PUDSP _V5.pdf Markup Summary

**PUD PRELIMINARY PLAN
GRANDVIEW RESERVE FILING 1**

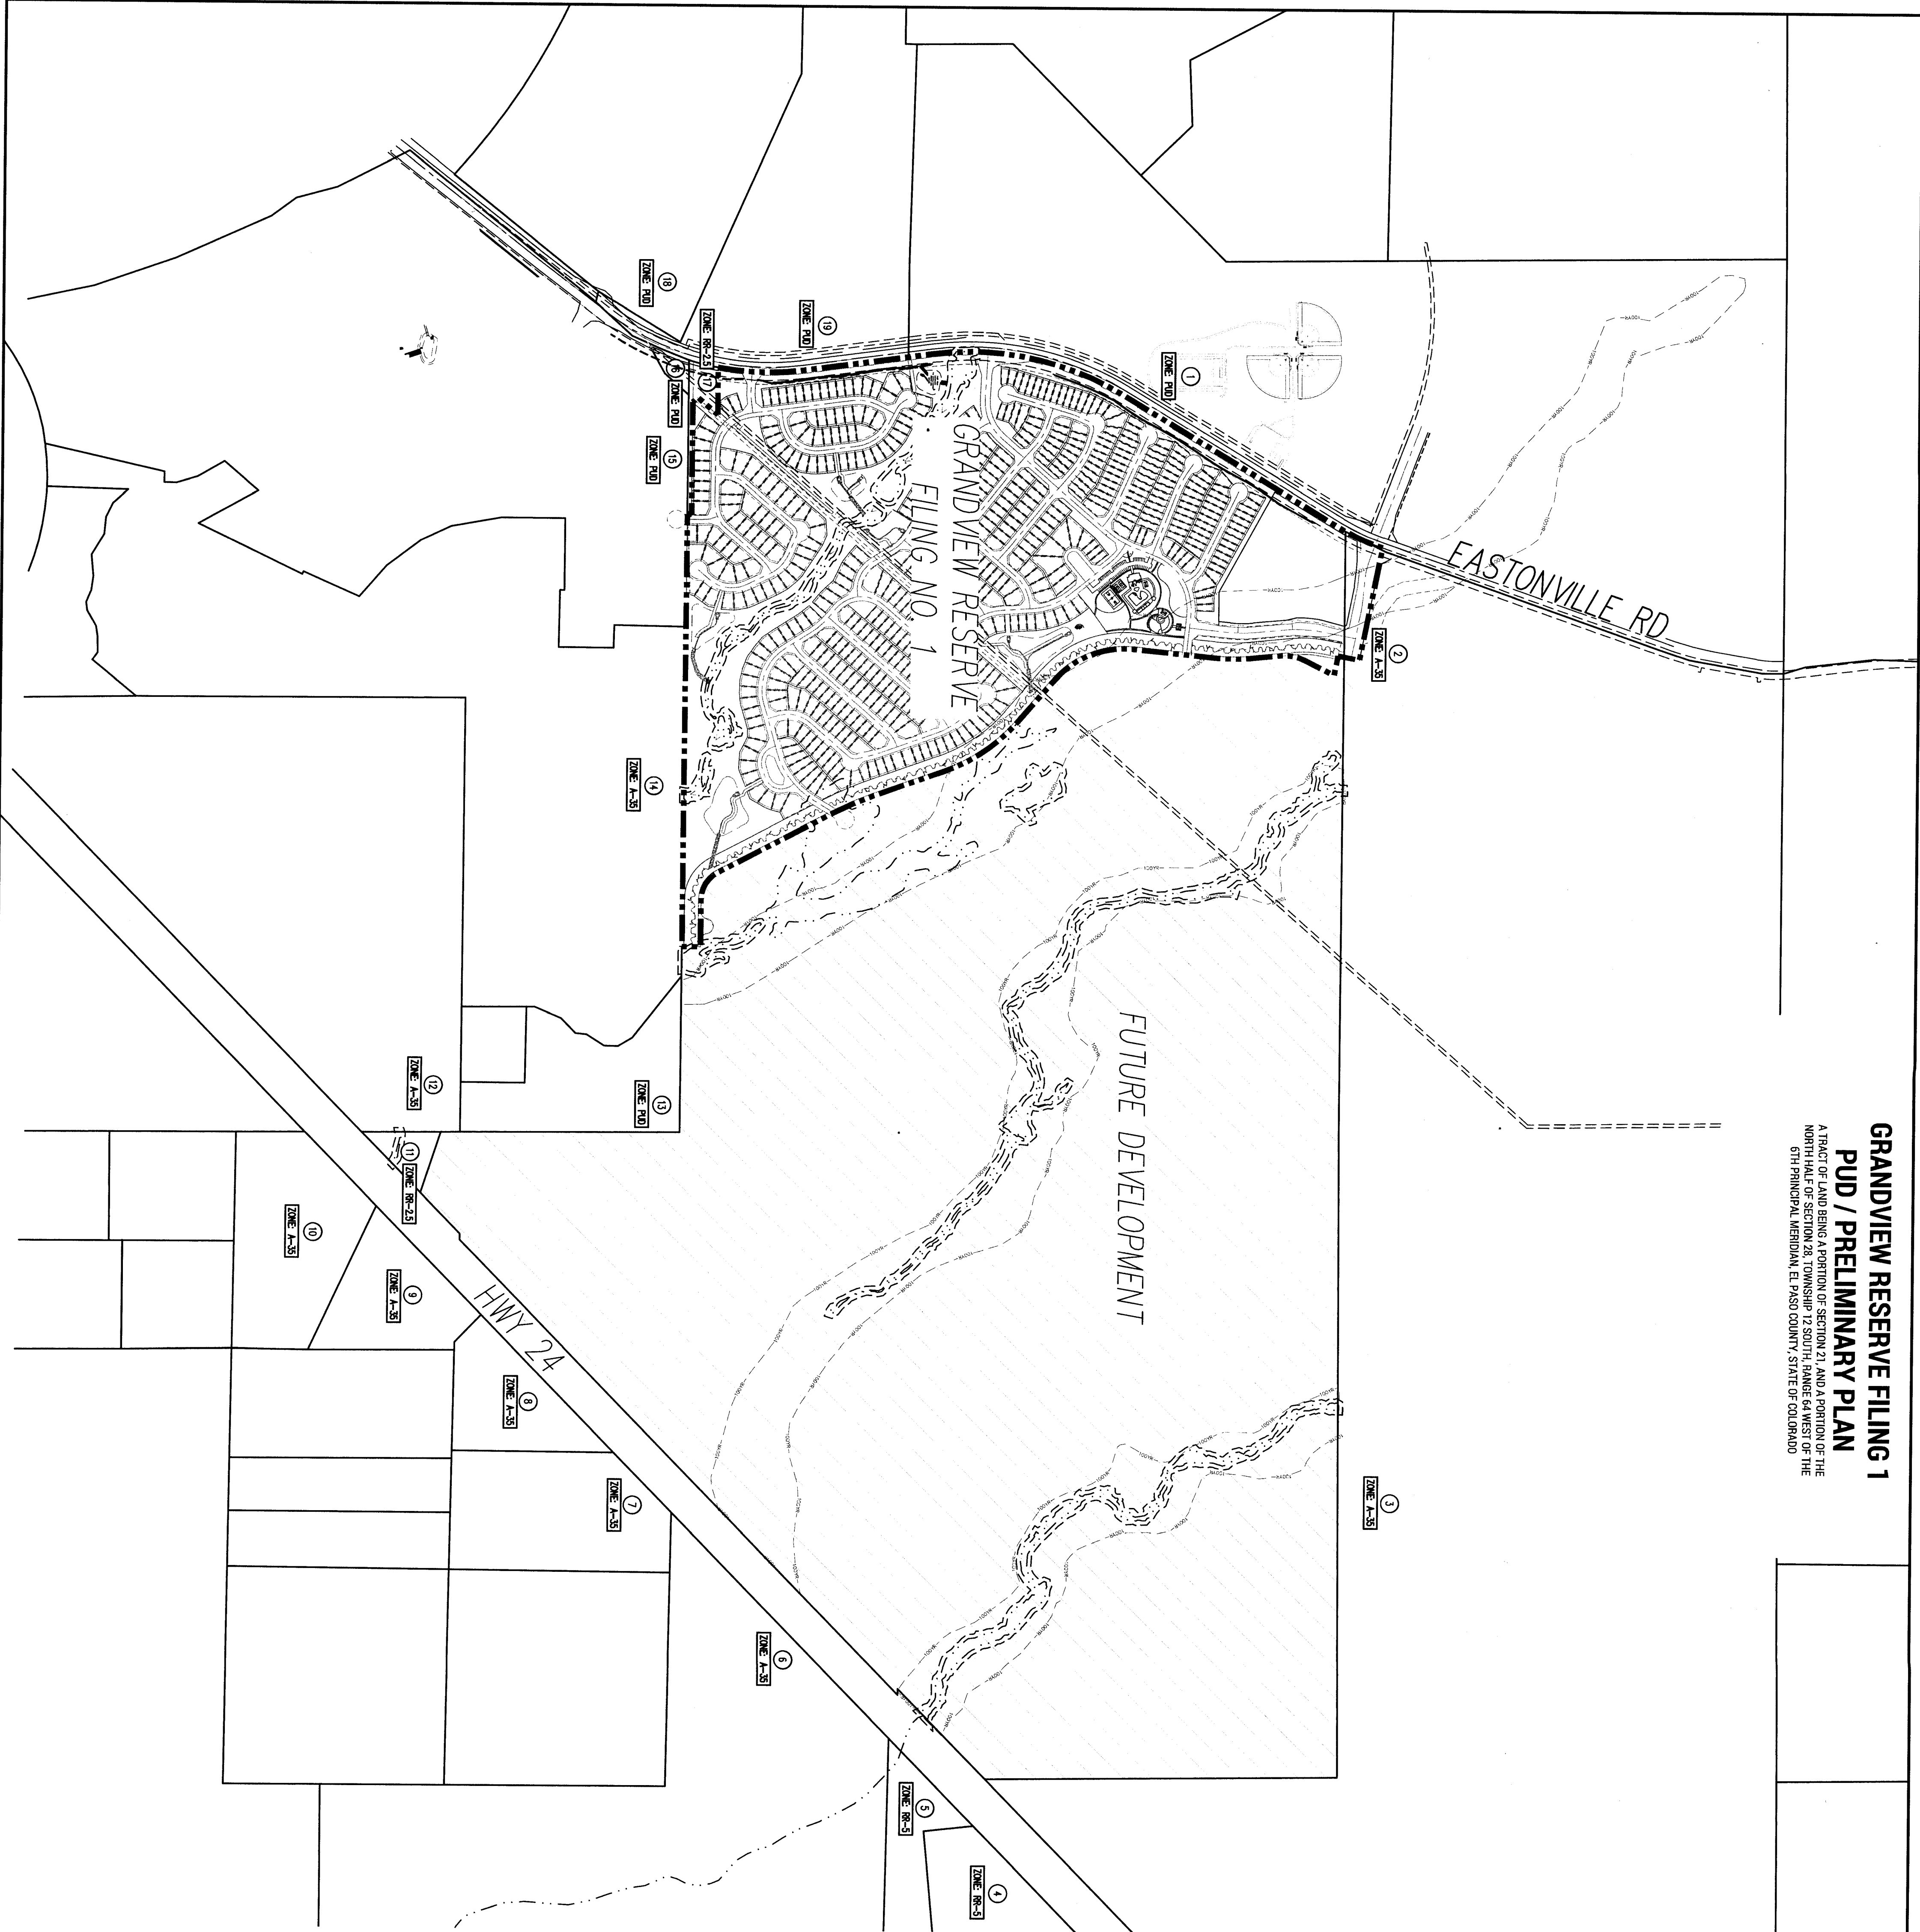
Subject: Callout
Page Index: 1 189.479 acres
Date: 6/22/2022 10:39:17 AM
Author: dsdrice
Color: ■
Layer:
Space:
Page Label: [1] COVER

Subject:
Page Index: 1 189.45
Date: 6/22/2022 10:39:29 AM
Author: dsdrice
Color: ■
Layer:
Space:
Page Label: [1] COVER
